20 April 2017

SF2017/037839; WST17/00033

SSD6456: Narrabri Gas Project

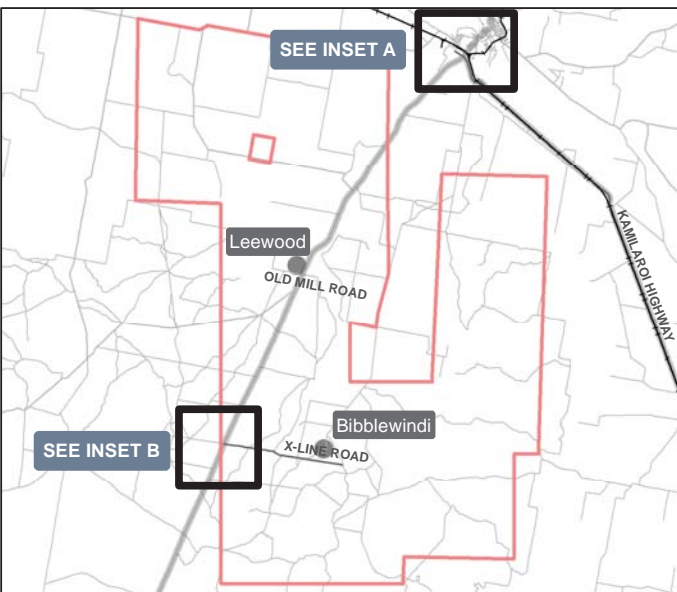
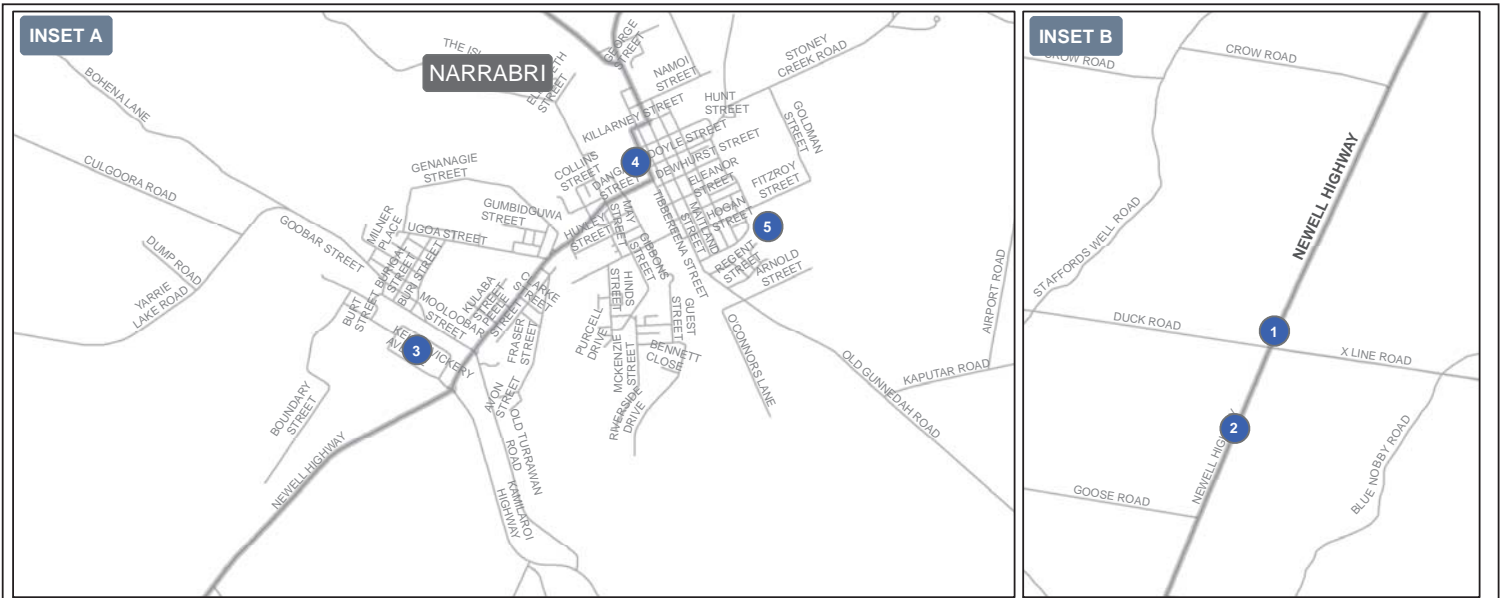
The EIS has been reviewed and Roads and Maritime notes that access to/from the Newell Highway from/to the project sites will be obtained via its intersections with X-Line Road and Old Mill Road. Access to the Westport Drillers Camp will also be via the X-Line Road/Newell Highway intersection with project generated traffic only using Westport Road and the intersection of Westport Road and the Newell Highway in extreme circumstances.

- The intersection of X-Line Road and the Newell Highway is to be upgraded to include sealed Auxiliary Left Short [AUL(S)] and Basic Right (BAR) turn treatments in accordance with Figures 8.3 & 7.5 Part 4A *Austrroads Guide to Road Design* respectively (copies enclosed) and relevant Roads and Maritime supplements. The intersection works are to be designed and constructed to accommodate the largest vehicle accessing the intersection. Such designs are to be appropriate for the current speed zone of 110km/h.

- The intersection of Old Mill Road and the Newell Highway is to be upgraded to include a Channelised Right (CHR) turn treatment in accordance with Figure 7.7 Part 4A *Austrroads Guide to Road Design* (copy enclosed) and relevant Roads and Maritime supplements. The channelised right turn treatment is to be designed and constructed to accommodate the largest vehicle accessing the intersection and be appropriate for the current speed zone of 110km/h.

- X-Line Road and Old Mill Road are to be sealed, and the seal maintained for the life of the project, a minimum of 30 metres from the edge of the Newell Highway travel lanes.
